Response to Submissions

Hera Mine Modification 3 PA 10_0191

September 2015

Figure 2  
AMENDED FINAL LANDFORM  
AND END LAND USE

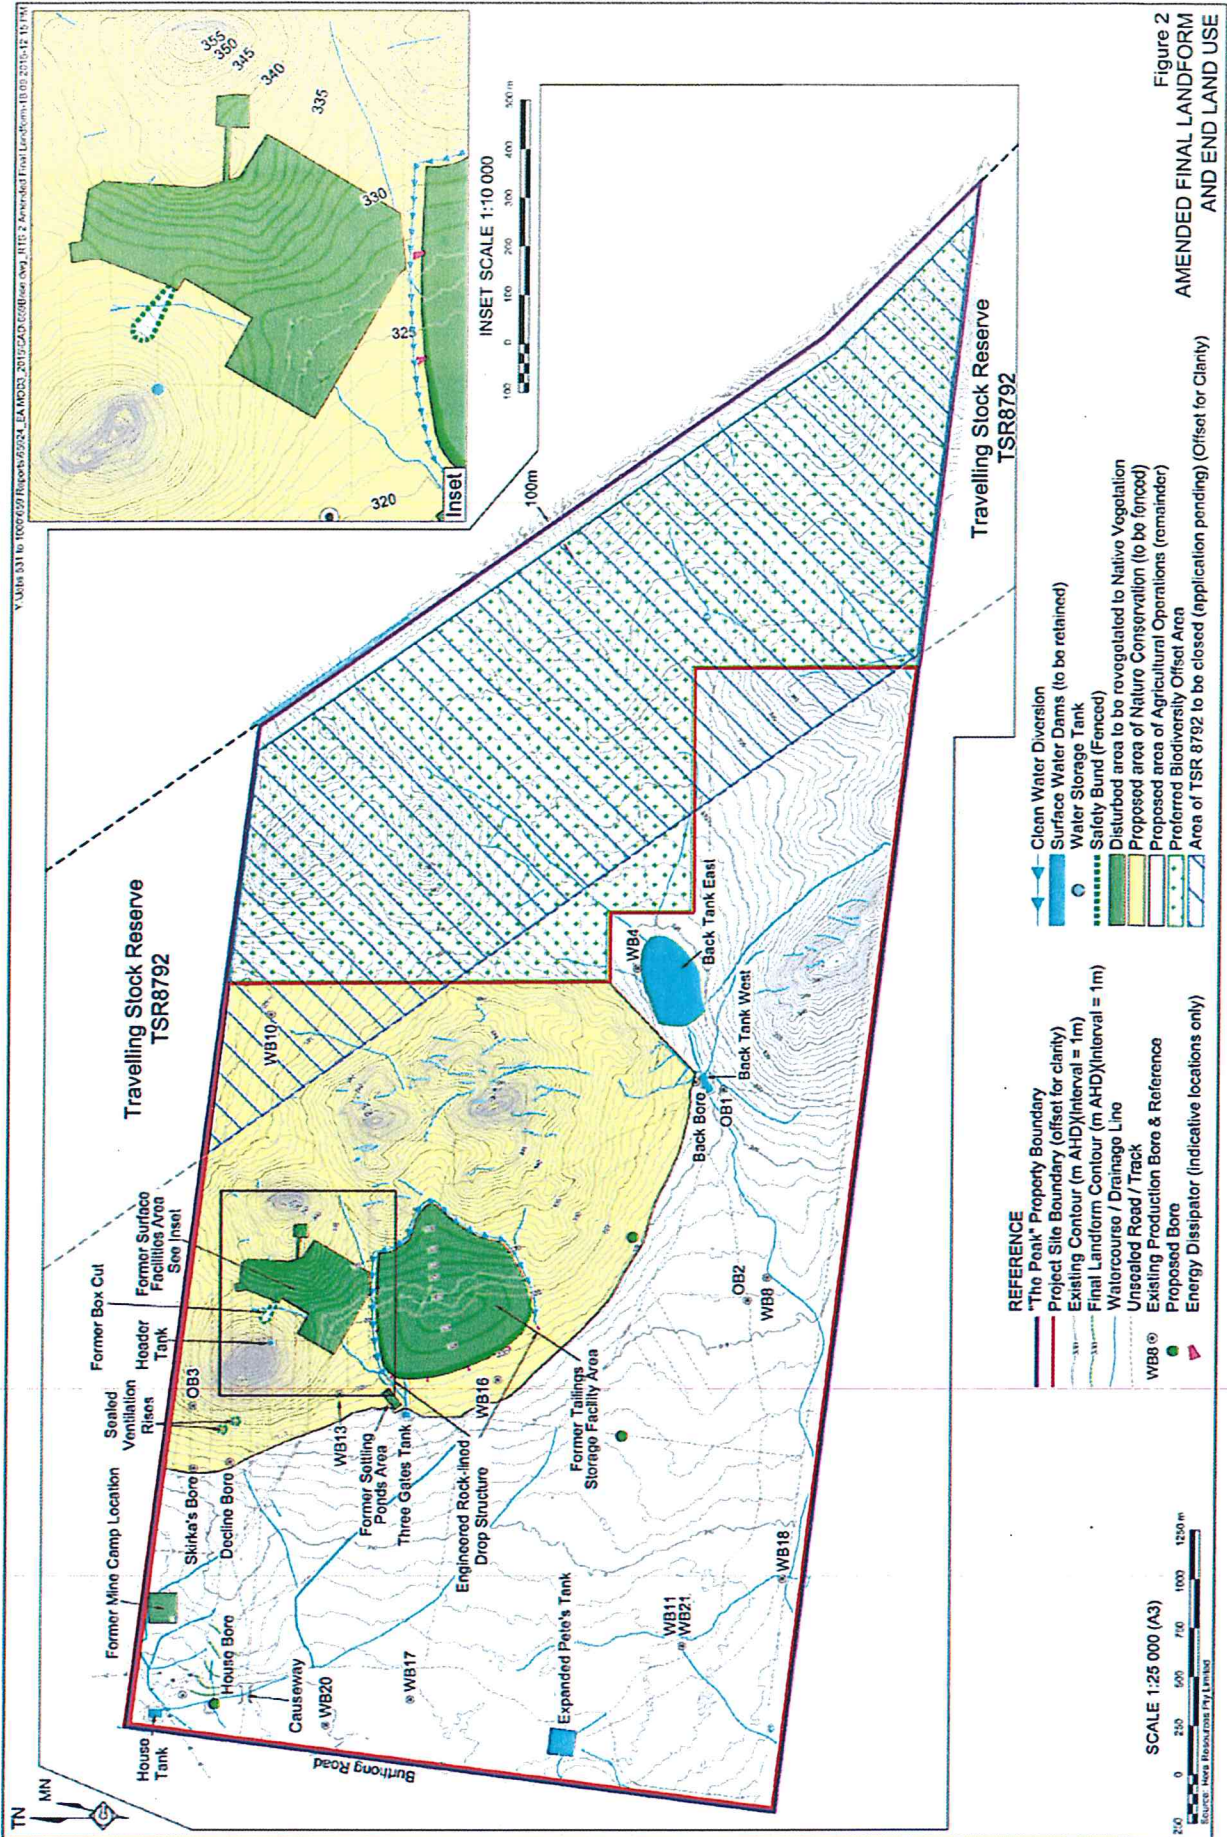
The EA does not provide detail of the revised final landform figure and that there is no a definitive commitment to the remove of material stockpiled at the proposed Northern WRE.

The Division requires a figure that depicts the proposed final landform and land use(s) for the project area, and surrounding undisturbed environment. Include contours, vegetation types, drainage infrastructure and any other retained built infrastructure; and confirmation that there is no change to the current commitment to completely remove all stockpiled waste rock prior to closure as described in the 2011 EA.

Figure 2 presents the proposed final landform for the Project Site, taking into account the Proposed Modification. In summary, the Proponent would ensure that the following is implemented during rehabilitation of the Mine Site.

- All potentially acid forming waste rock within the Southern Waste Rock Emplacement would be transported back underground and placed with areas to be inundated with groundwater.
- All non-acid forming waste rock remaining within the proposed Northern Waste Rock Emplacement and the ROM pad would be used for rehabilitation purposes, including (in priority order):
 - capping of the Tailings Storage Facility;
 - establishment of surface water controls on the final landform; and
 - backfilling or partially backfilling of the box cut.
- The proposed disturbed areas would be rehabilitated as described in Section 2.9.5 of RWC (2015) and the MOP.
